Goulburn Hospital and Health Service Re-development ECI Main Works

Project: Goulburn Hospital – Main Works project

Date: November 26, 2019

Subject: Response to SSDA Submission

SITE PLAN

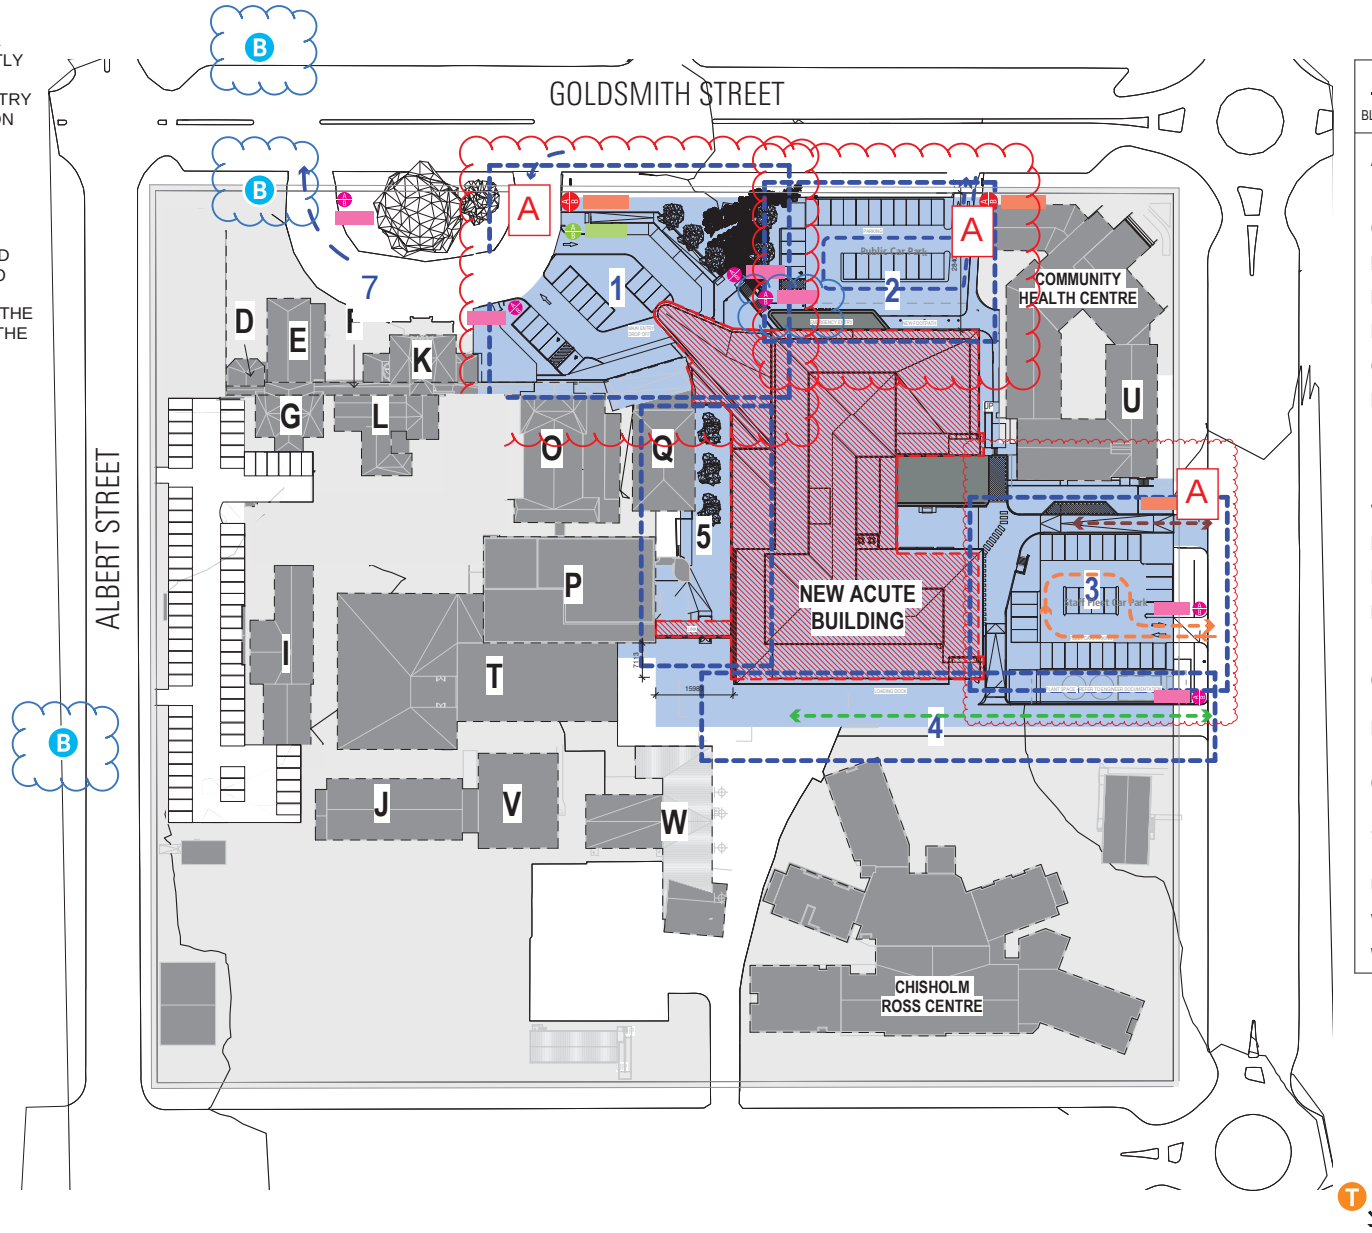
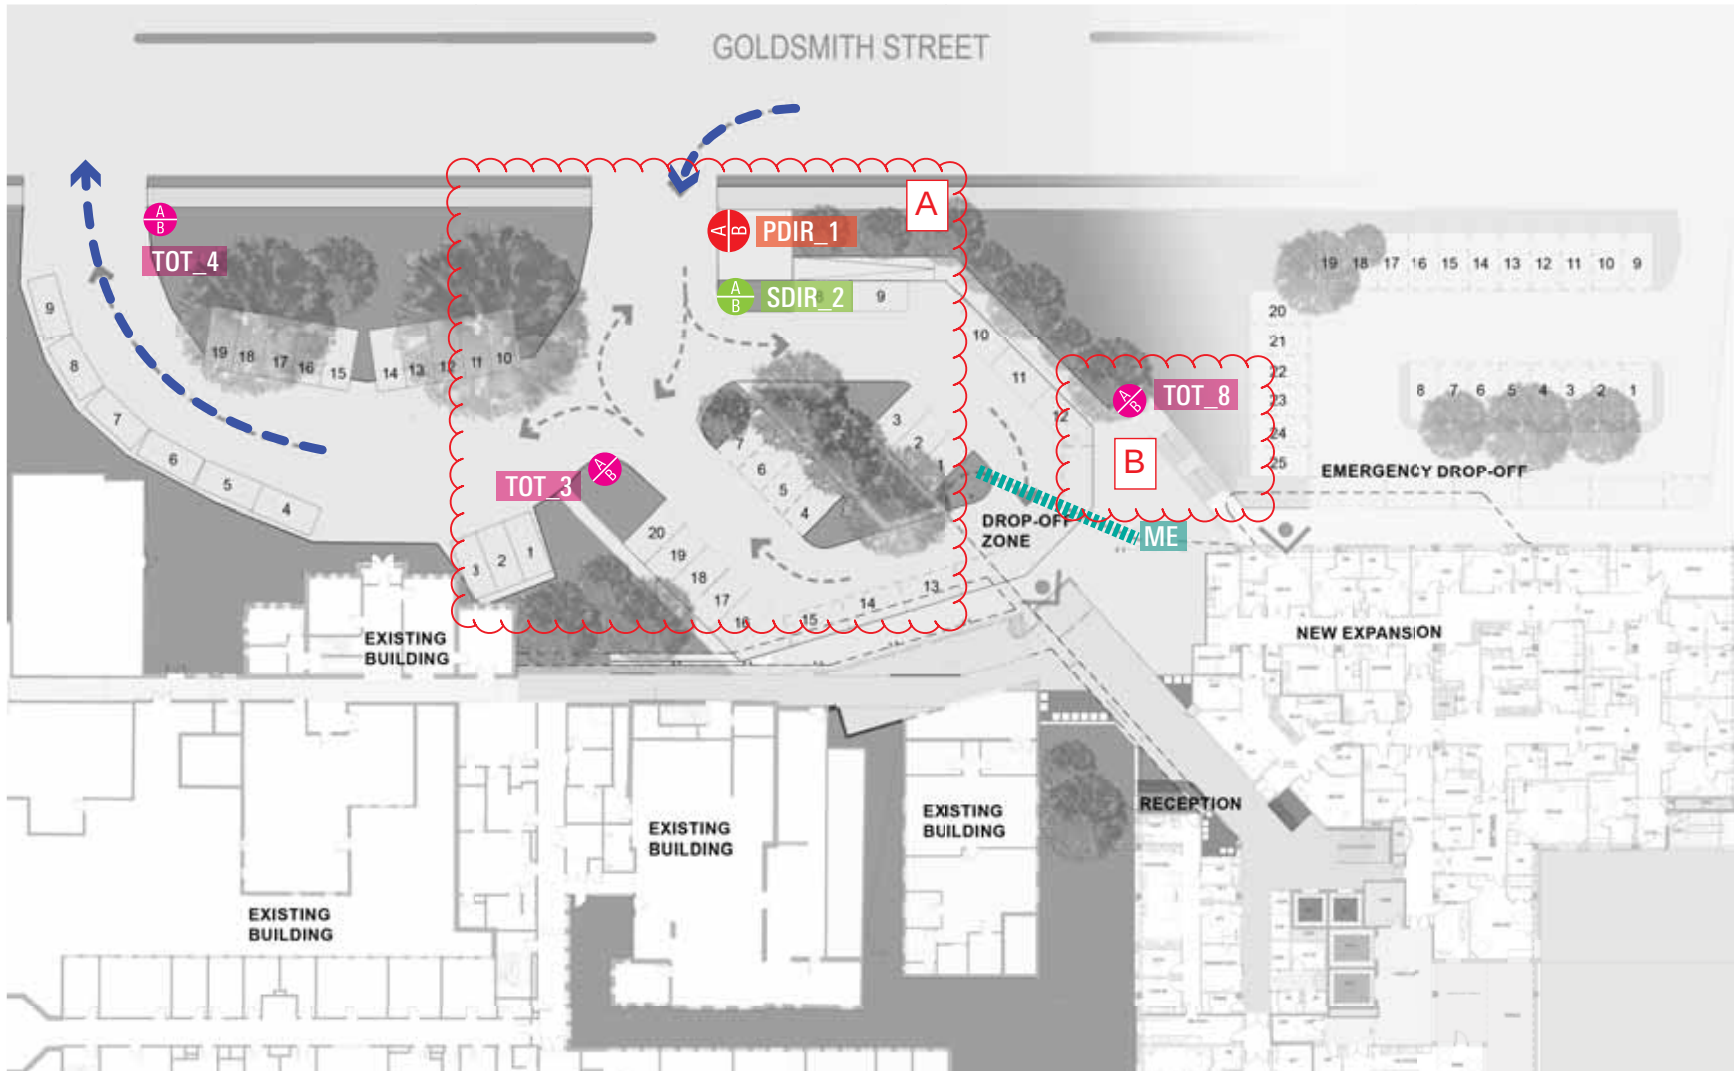
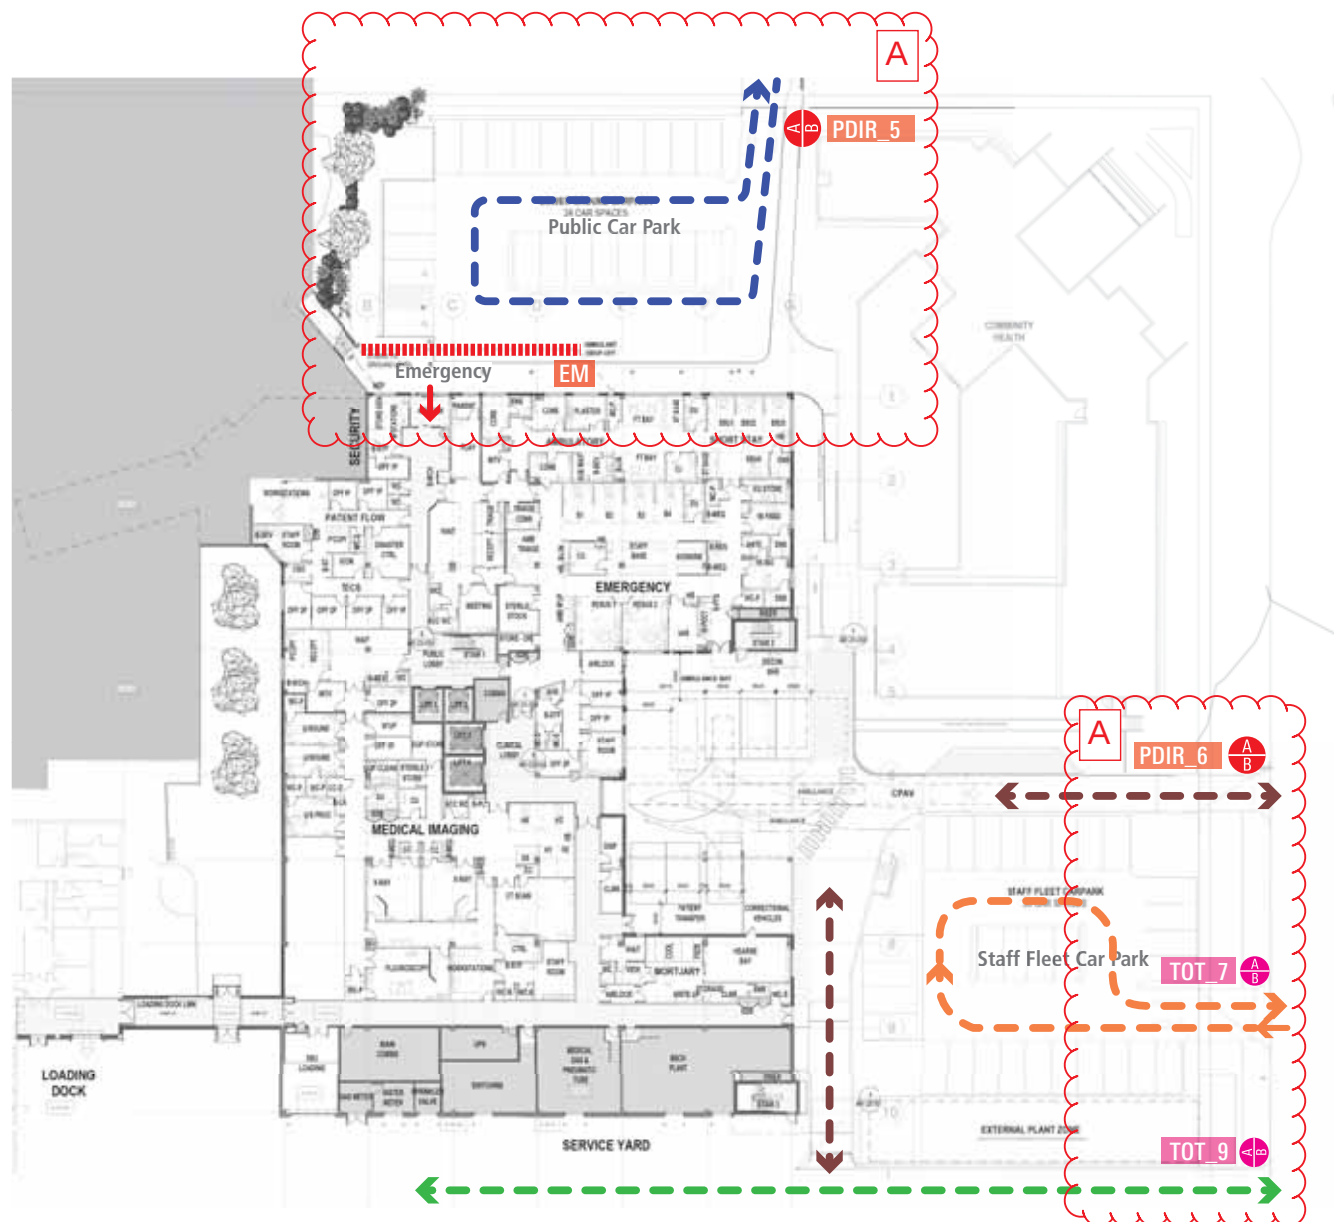
- *include wayfinding strategies and travel access guides along with the signage modifications to assist with increasing the mode share of walking, cycling and public transport. It is recommended that wayfinding to the nearby bus stops at Goldsmith St and Albert St is included.*

Please refer consultant's response in the appendixes attached.
